October 31, 2011

**RE: 171 Warren Avenue**

**Project ID: #10-79900021**

On October 7<sup>th</sup>, 2011 you submitted final plans to reflect the as-built development at this site. These plans confirm that the minor changes outlined in July, 2011 also included some substantial changes that were not mentioned in the earlier correspondence nor shown on the sketch plan: an increase in parking from the permitted 9 spaces to 23 spaces; reduced parking aisle widths; and the placement of boulders within the City's right-of-way. These changes do not meet the review standards of the site plan ordinance, and in particular we cannot approve the location of boulders in the right- of -way.

Drawing file: submitted as asbuilts Oct 2011 / NOT APP 32209POULIN-ASBUILT 24x36-10-06-11.pdf

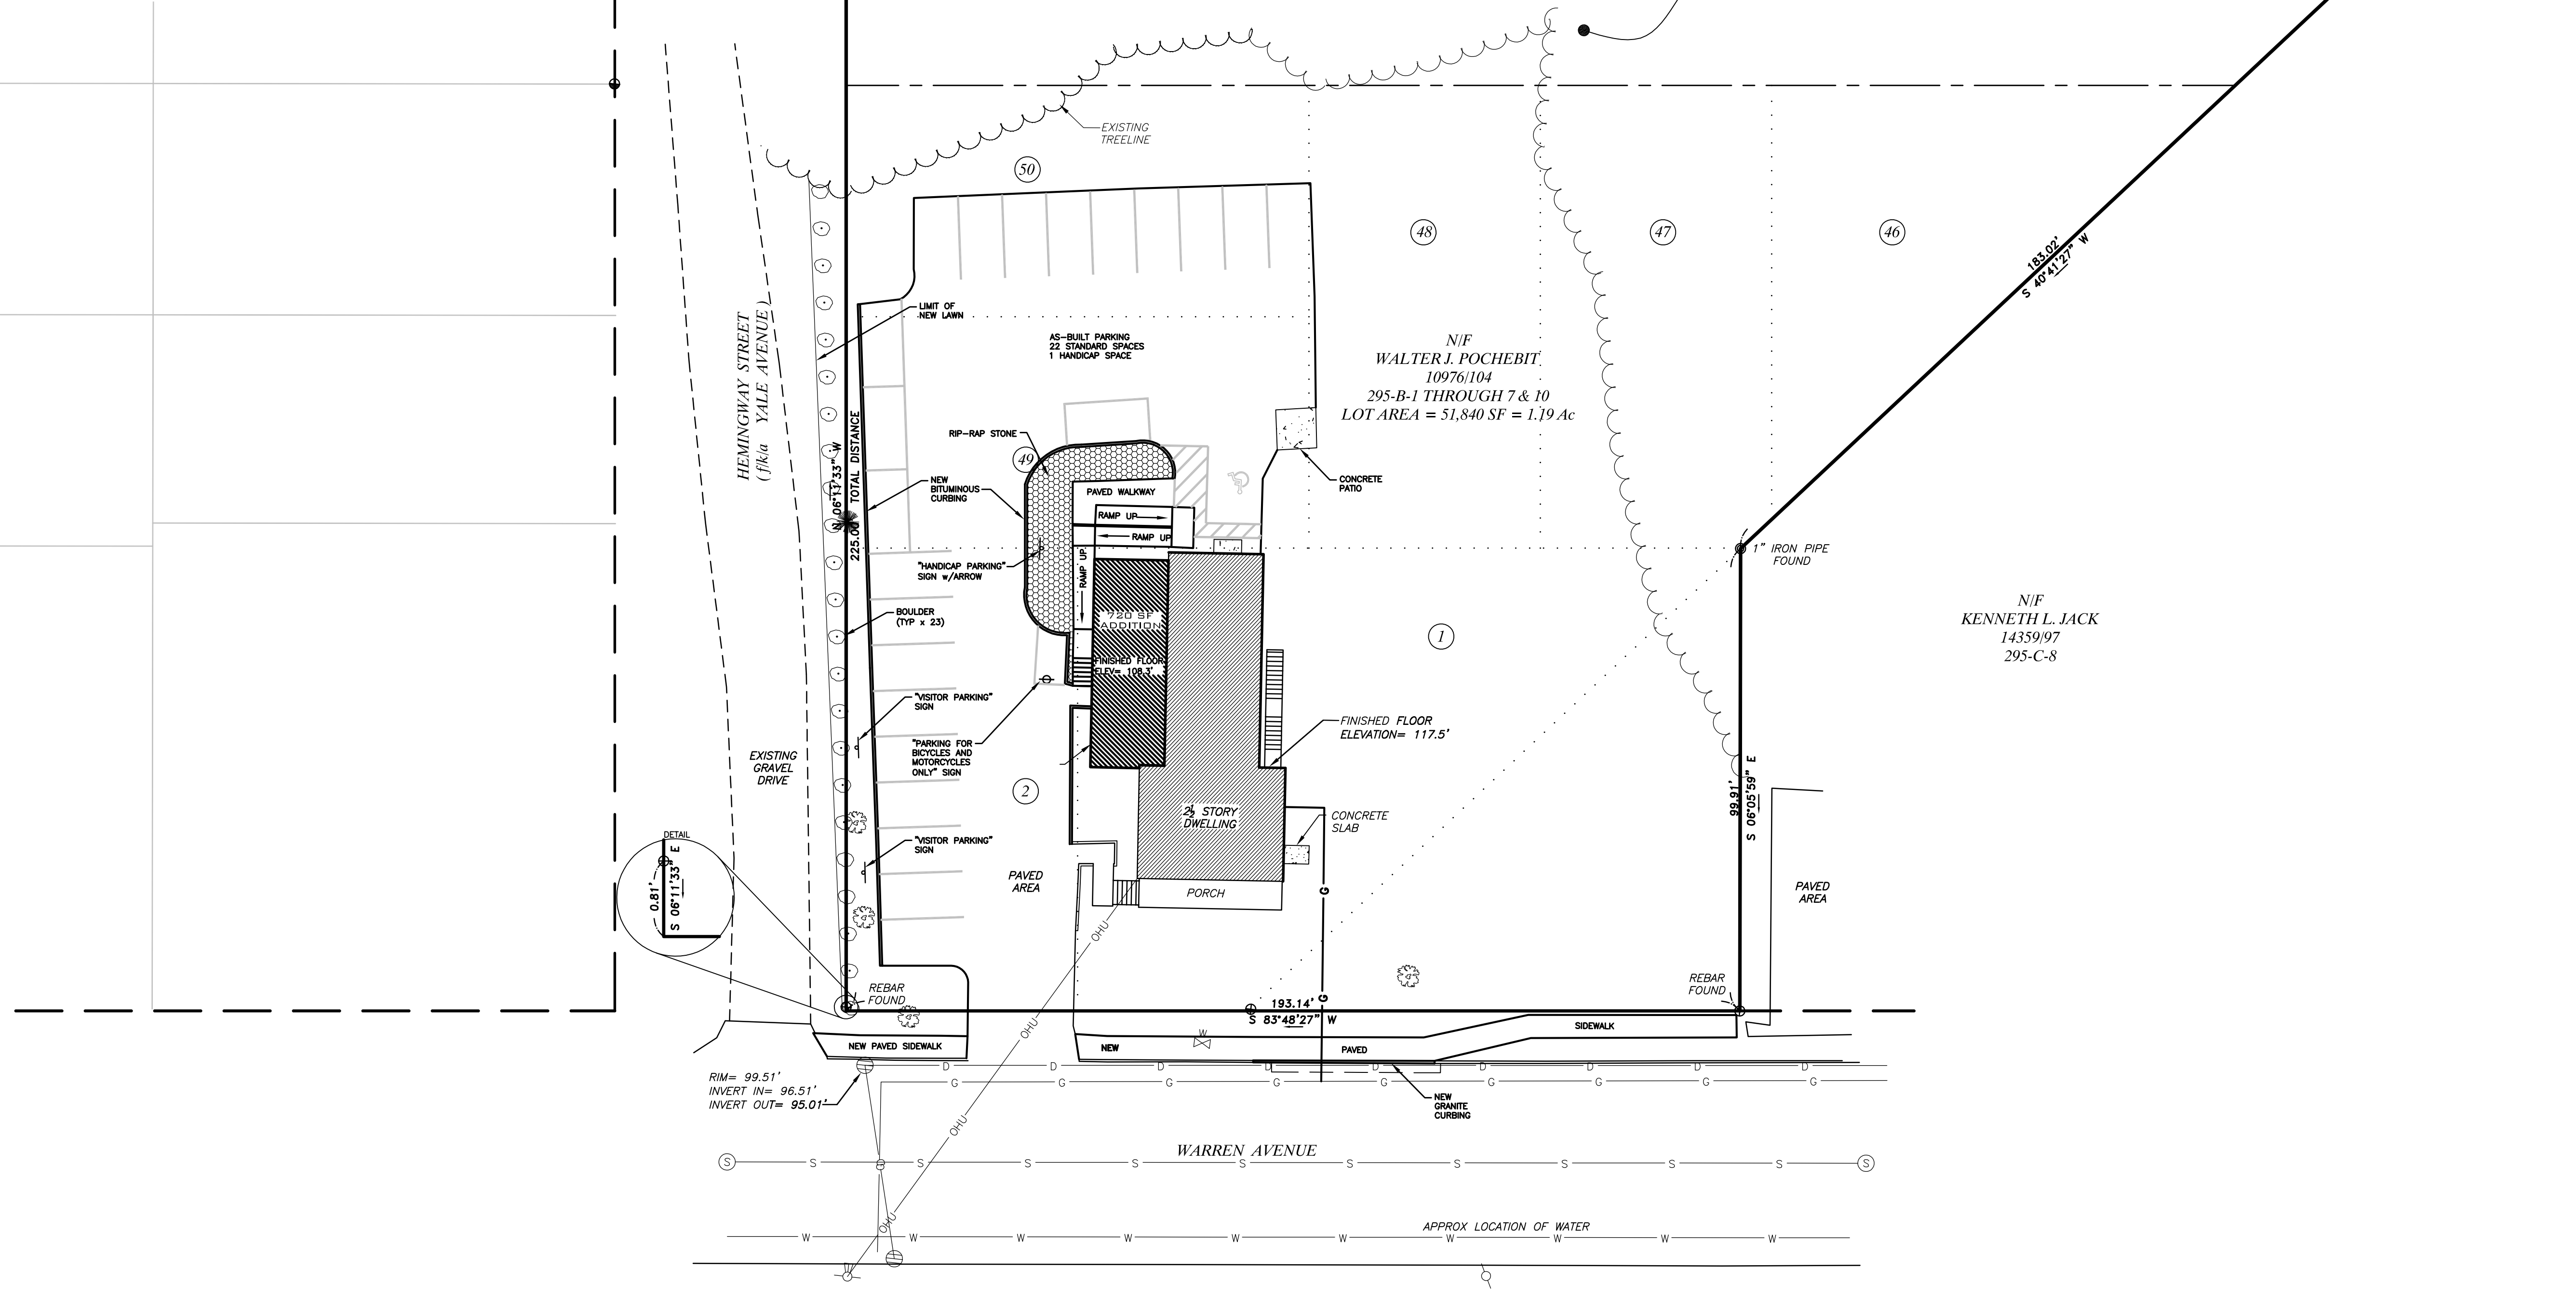
- Relocate the boulders so that all are within your property- an alternative is for you to explore the possibility of obtaining a revocable license through the Legal Department as such a license may allow the boulders to remain in the ROW until such time as it is developed as a street; and

- Replace or modify the two light fixtures near the corners of the new addition facing Hemingway Street, so that the lights are directed downward and are full cut-off so that “lenses, refractors or lamp sources do not extend below the surface of the fixture housing and no direct light shall be directed at or above the horizontal plane” (Para.12.2.6 of *City of Portland Technical Standards, Section 12 – Site Lighting*); and

- Remove the striping for the two (2) 90 degree parking spaces located opposite the rip rap area, facing Hemingway Street and abutting the southern-most parallel space near Hemingway Street; and

- Plant two (2) trees (from the City’s recommended tree list, copy attached) in the “bump out” located at the northeast corner of the site; and
- Show these revisions and add the final grades on the final “as built” drawings and submit as 5 scaled paper sets, a pdf (via e-mail), and a CD or DVD containing the plan in AutoCAD format (\*.dwg), release AutoCAD 2005 or greater.
